Re: Undi Commerce Park – *Technical Review 3*
PA 22008

After preliminary review of the revised application materials for the above referenced proposal, the Planning Division has the following comments:

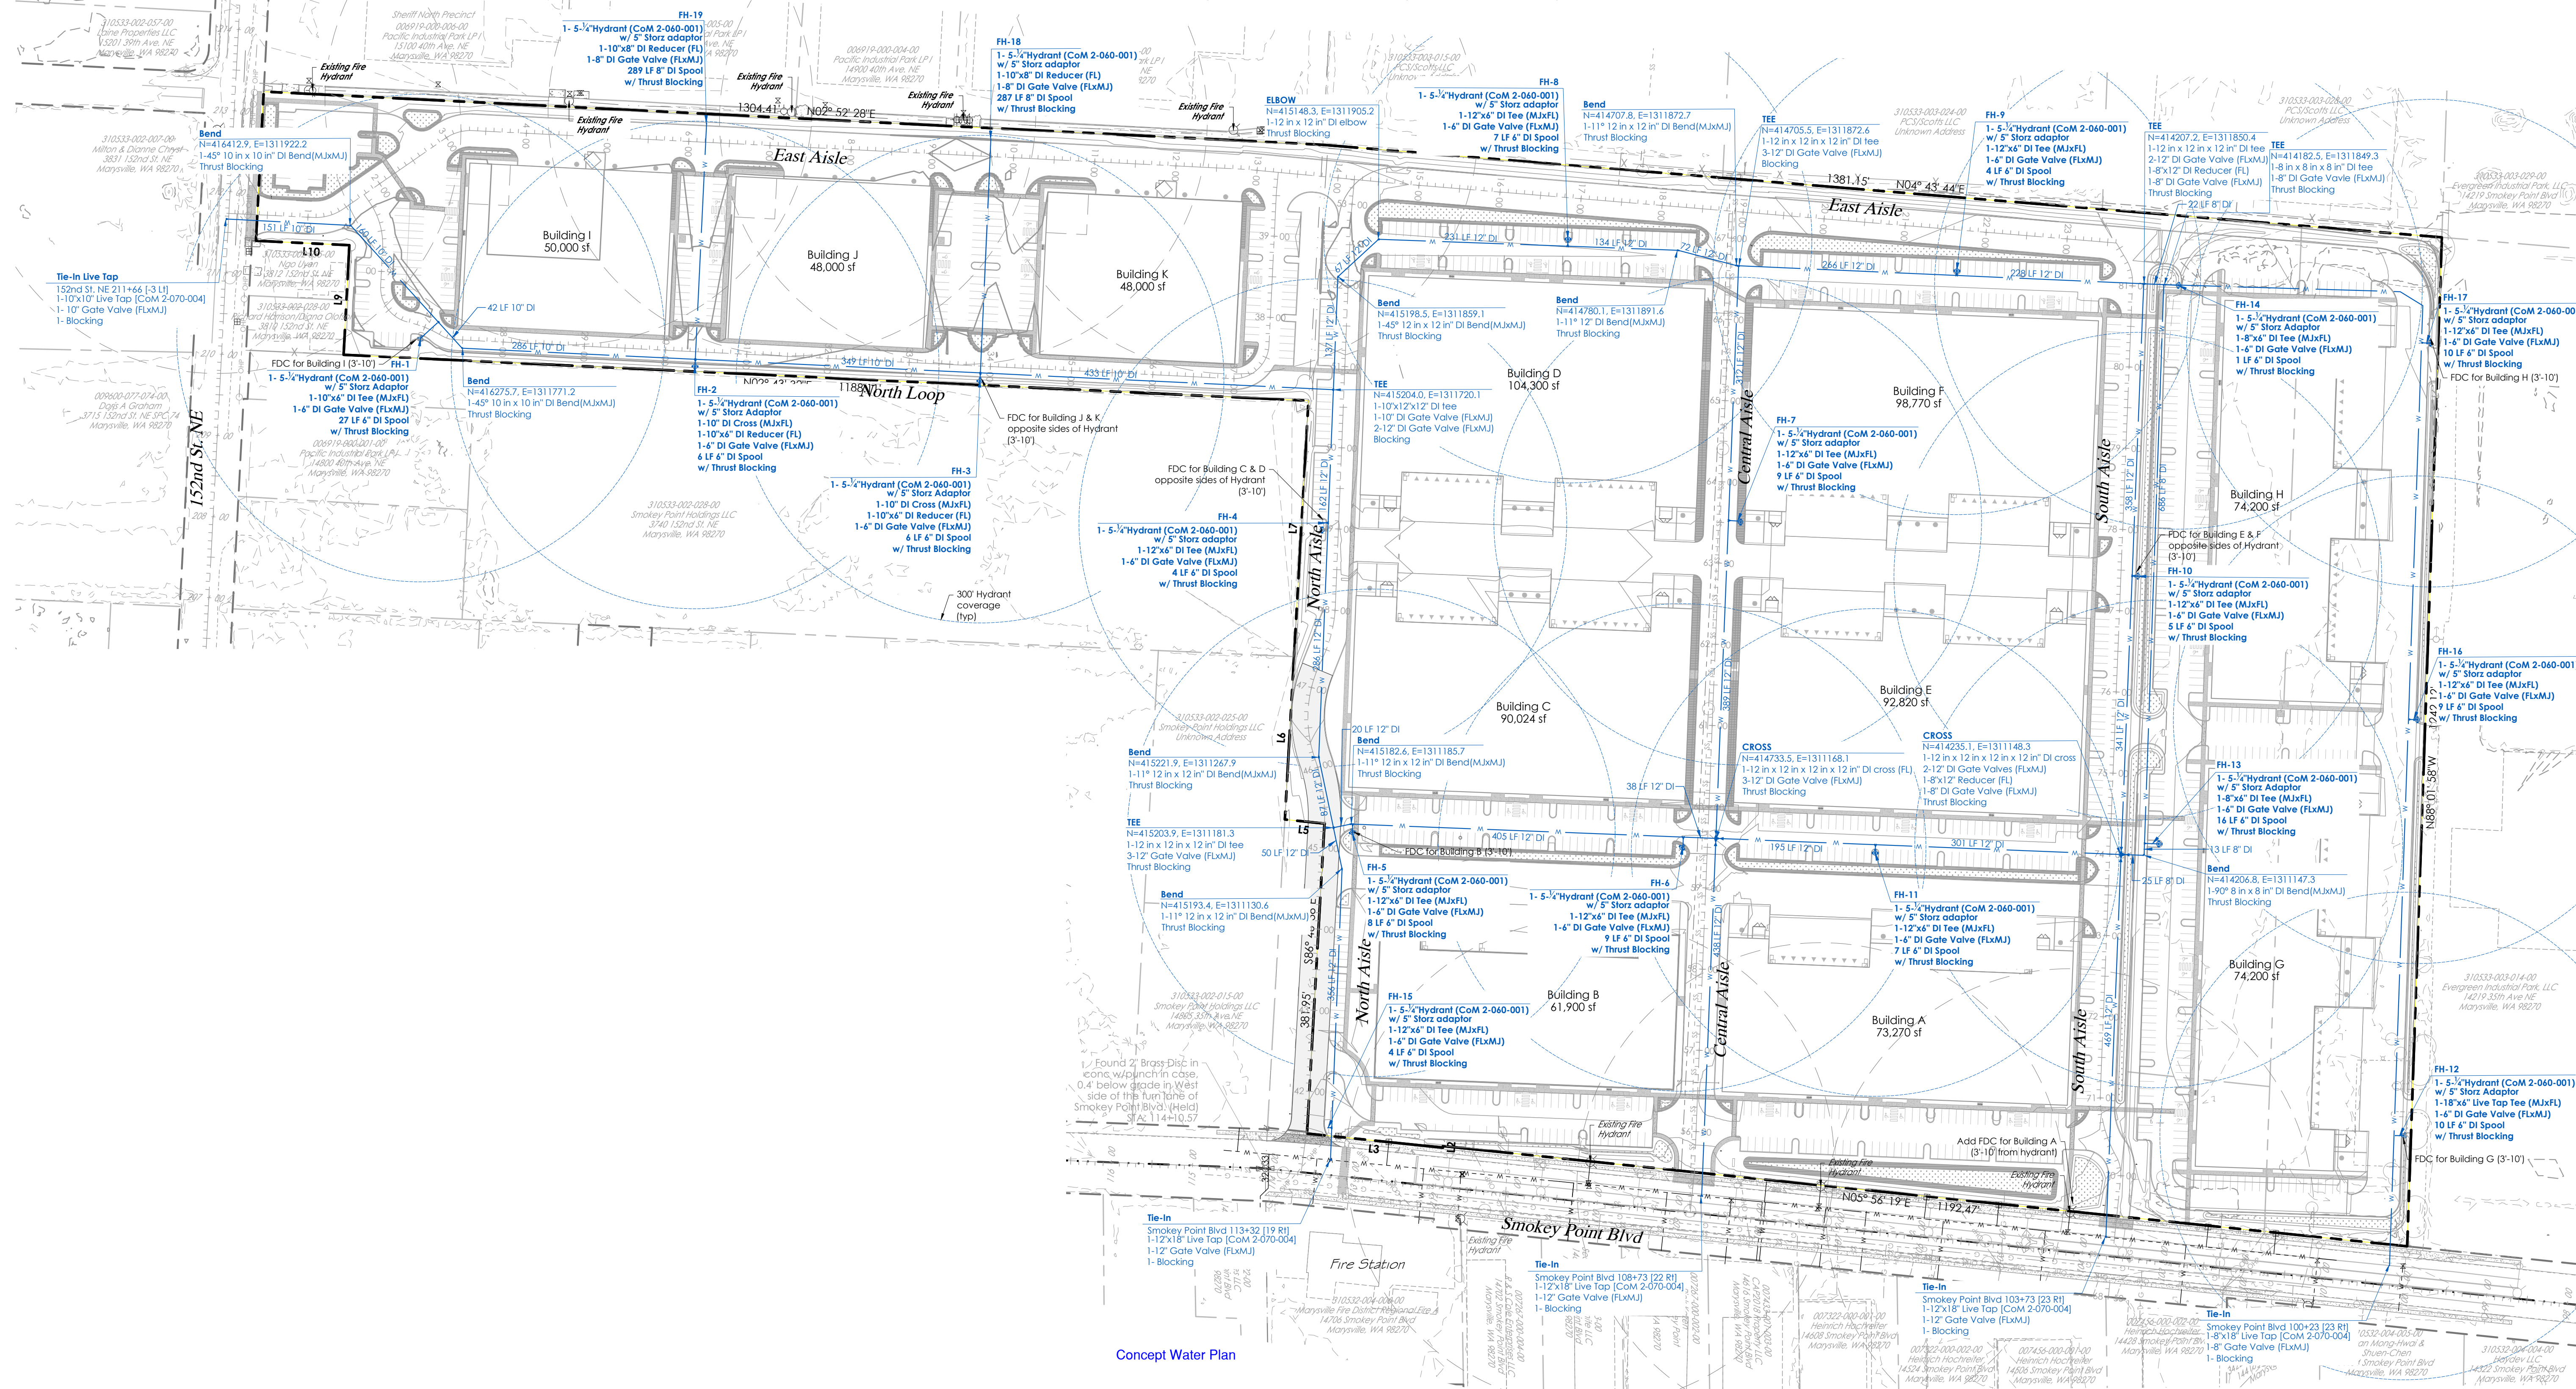
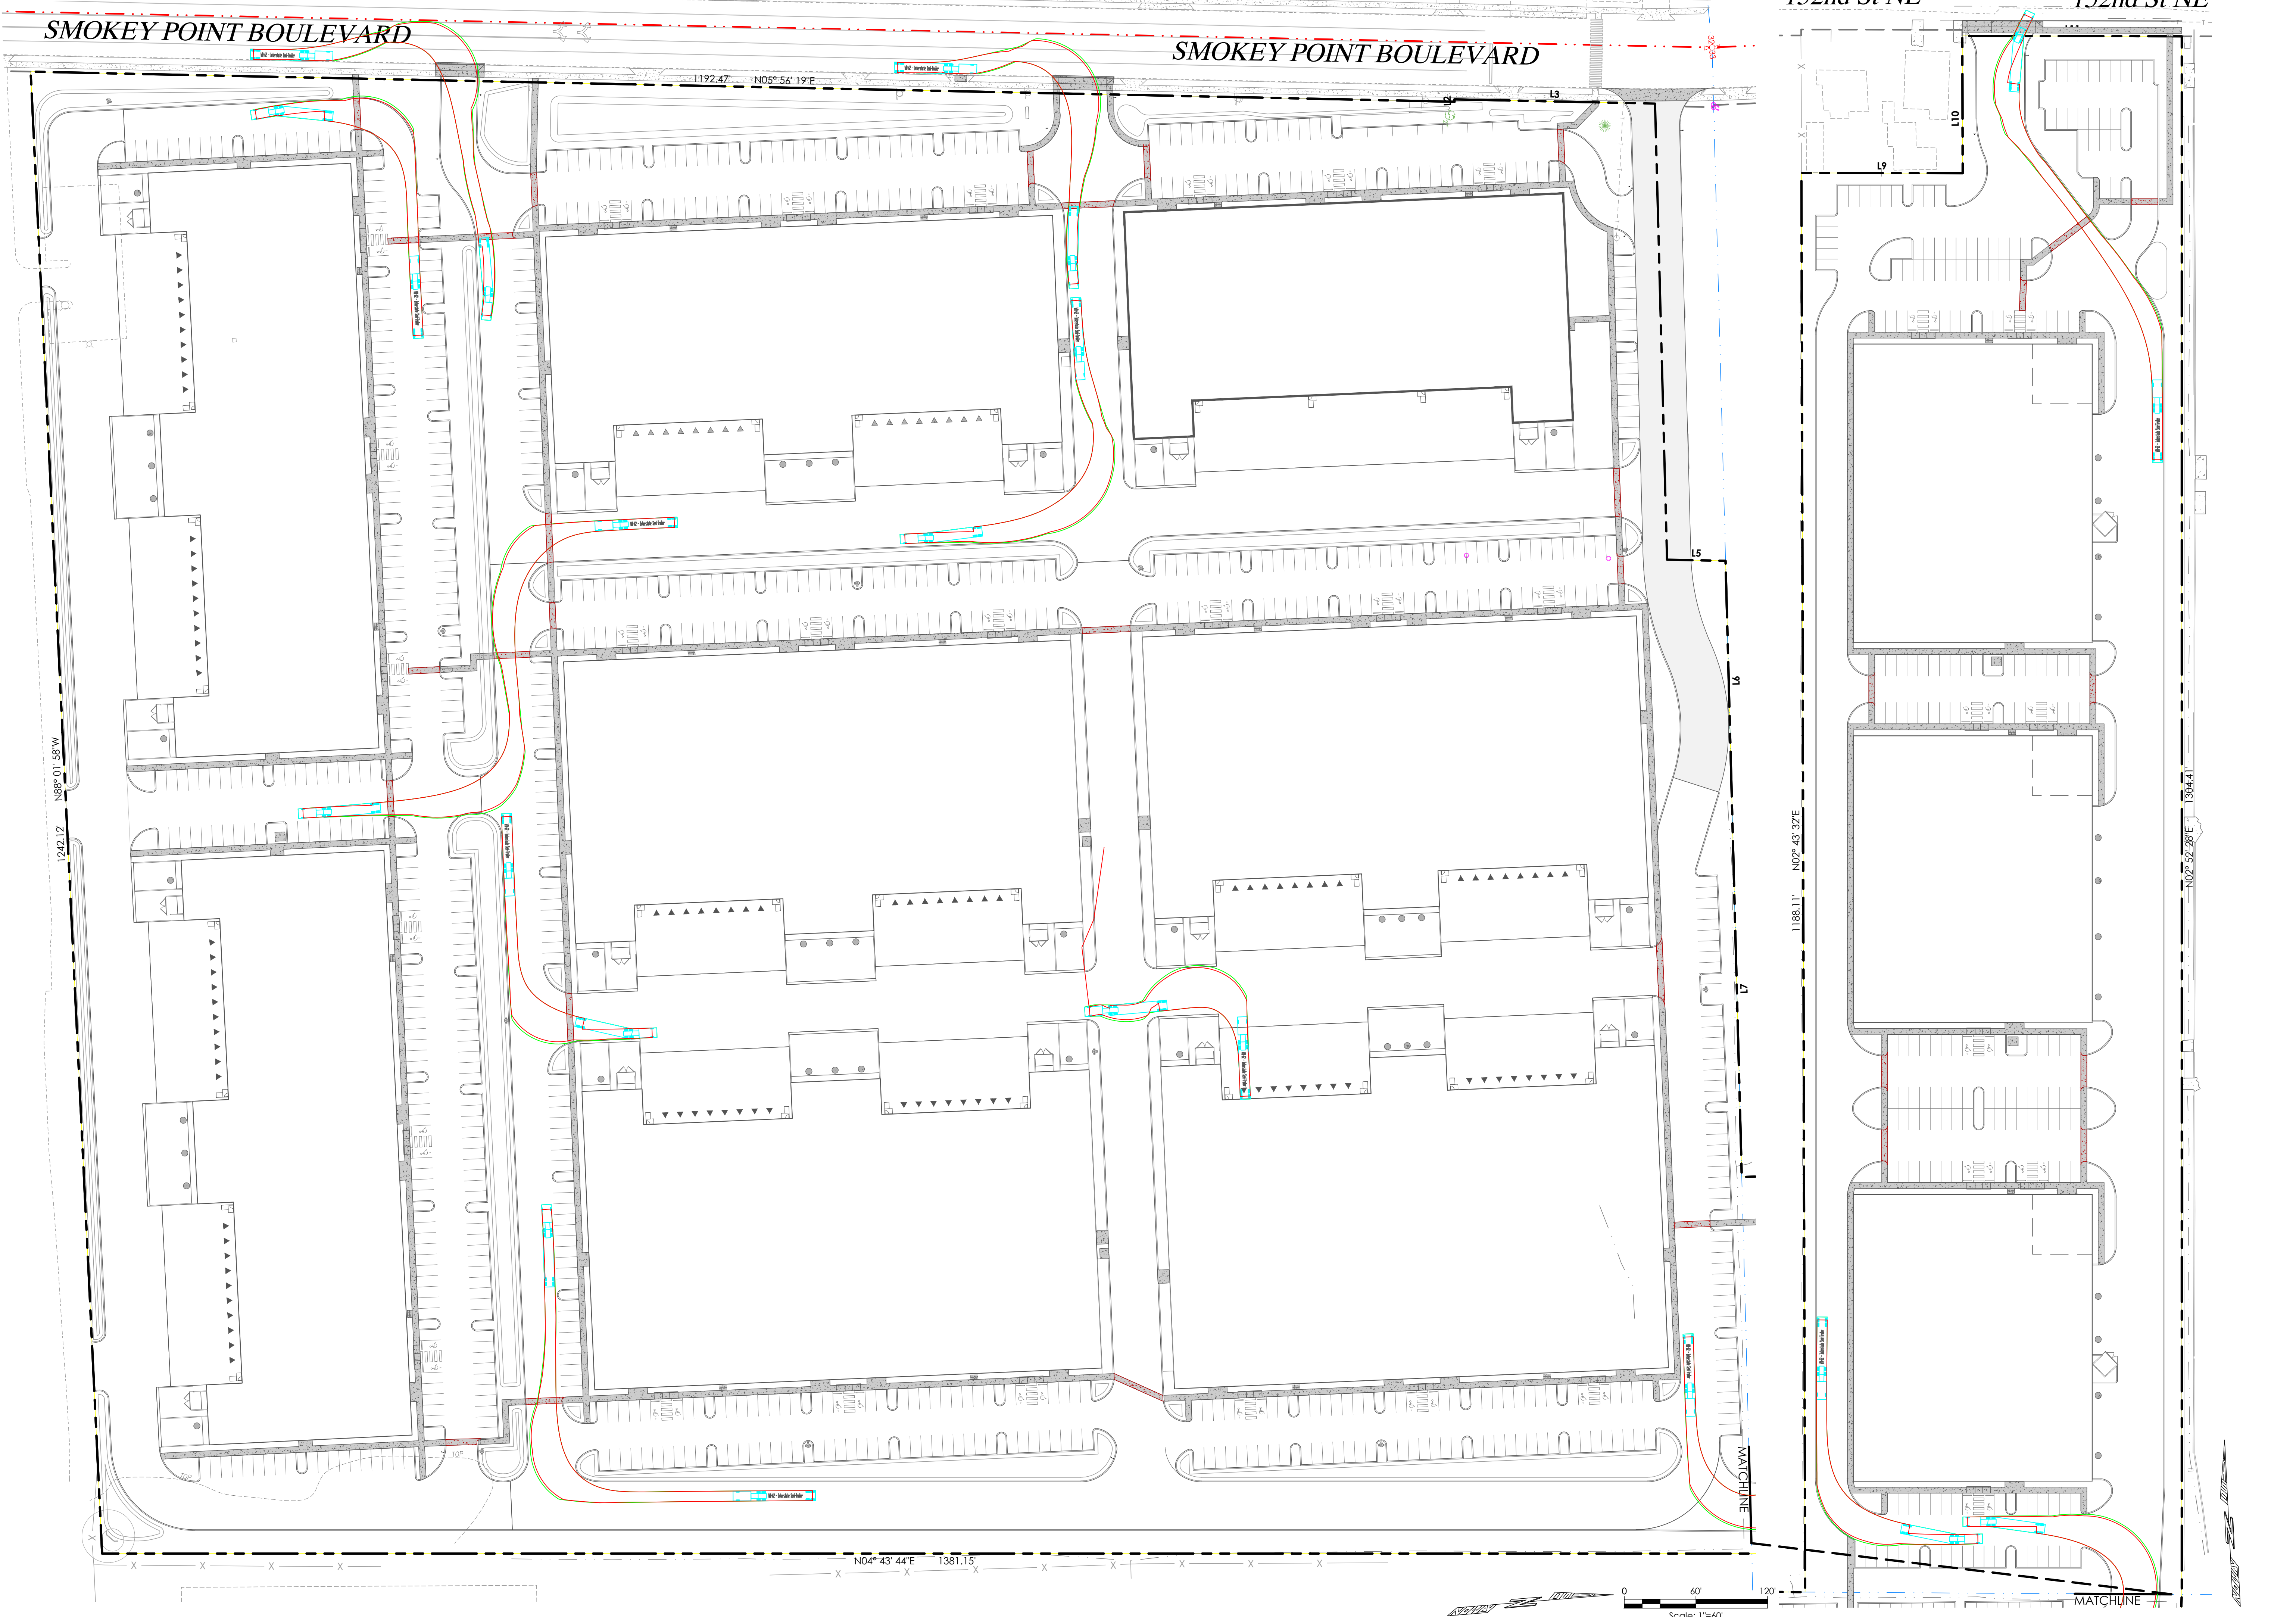
8. **WATER ISSUES:**
- a. Fire hydrants with approved water supply must be in service prior to building construction.
 - b. The number of fire hydrants shall be determined on an average spacing of 300 feet computed on an imaginary line parallel to and not less than 50 feet from the structure. All hydrants are to be accessible to fire department pumpers over roads capable of supporting such fire apparatus (City EDDS 2-060). *Plans show no hydrants available along the north end of the east aisle. Please add two hydrants; between buildings I – J and J – K.*

Conceptual Midblock Crossing Layout

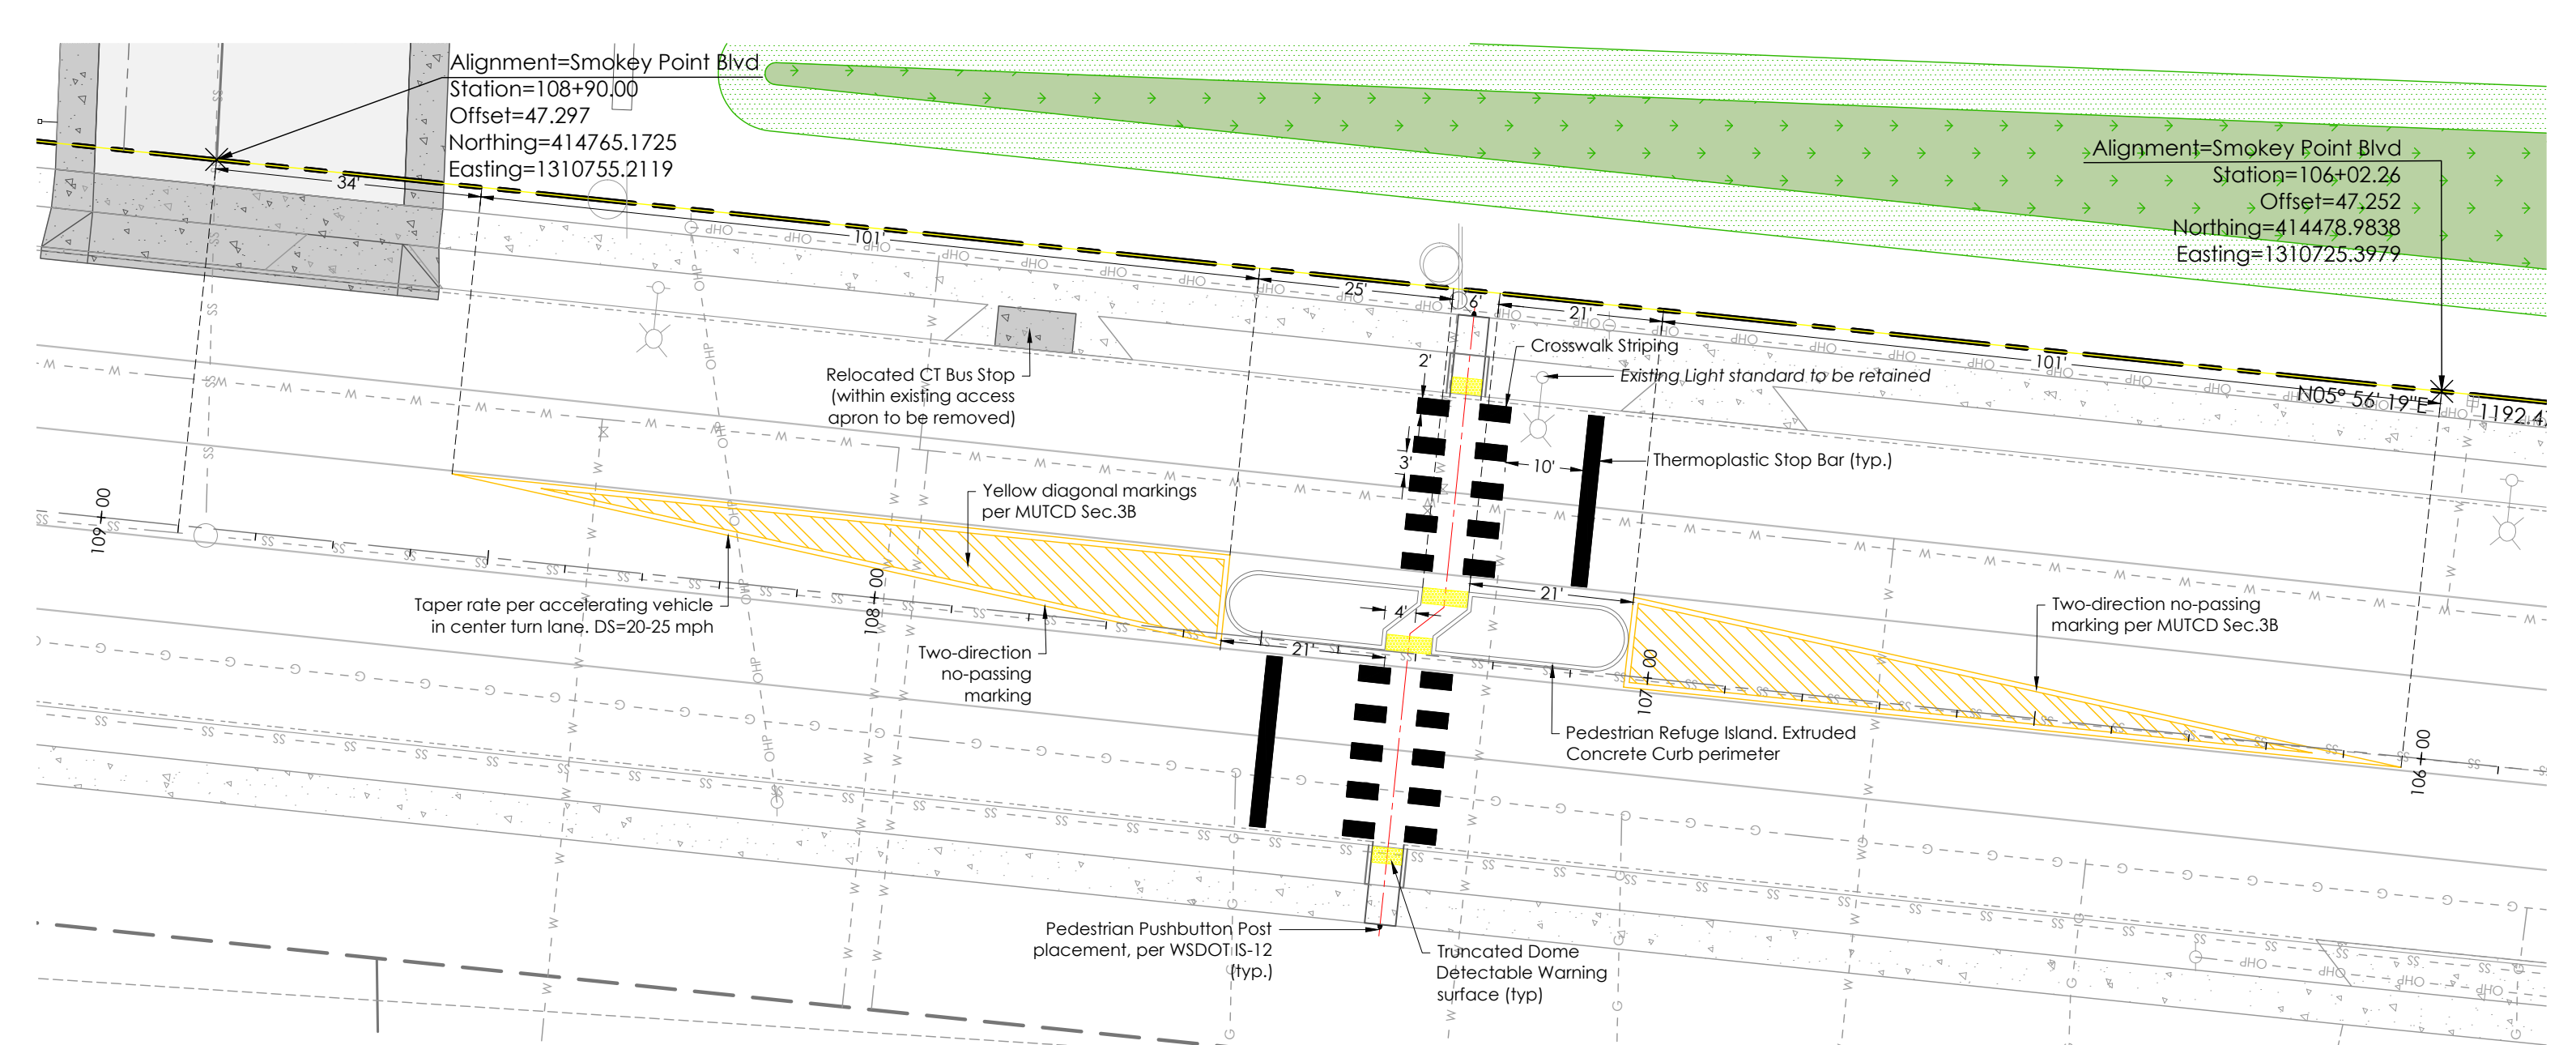
- iii. Public Works Traffic Division would potentially support a variance if the development were to provide for one of the following options:
 - A. Modification of the existing traffic signal to include signalization of the proposed shared driveway within the signal layout.

- B. The existing traffic signal would need to be reduced to an Emergency Fire Signal only by:
 - Reconfiguring span wire signal heads to provide for fire signal operations only.

- Relocating the existing pedestrian crosswalk contained within the traffic signal operations to the north or south with the installation of a marked two-stage offset mid-block crosswalk with RRFB systems. Fully built-out Pedestrian Median Refuge Island will be required with pedestrians having a 2-stage RRFB system with a non-direct through pedestrian path to encourage viewing of oncoming traffic. (See example at Grove ST & Bayview Trail west of 81st DR NE).

- CT Bus Stops on both east and west side of Smokey Point Blvd. will need to be relocated to be near relocated crosswalk with RRFB.
 - Location of proposed pedestrian crosswalk with RRFB shall be located to provide for the least negative impact to utilization of the existing two-way left turn lane.
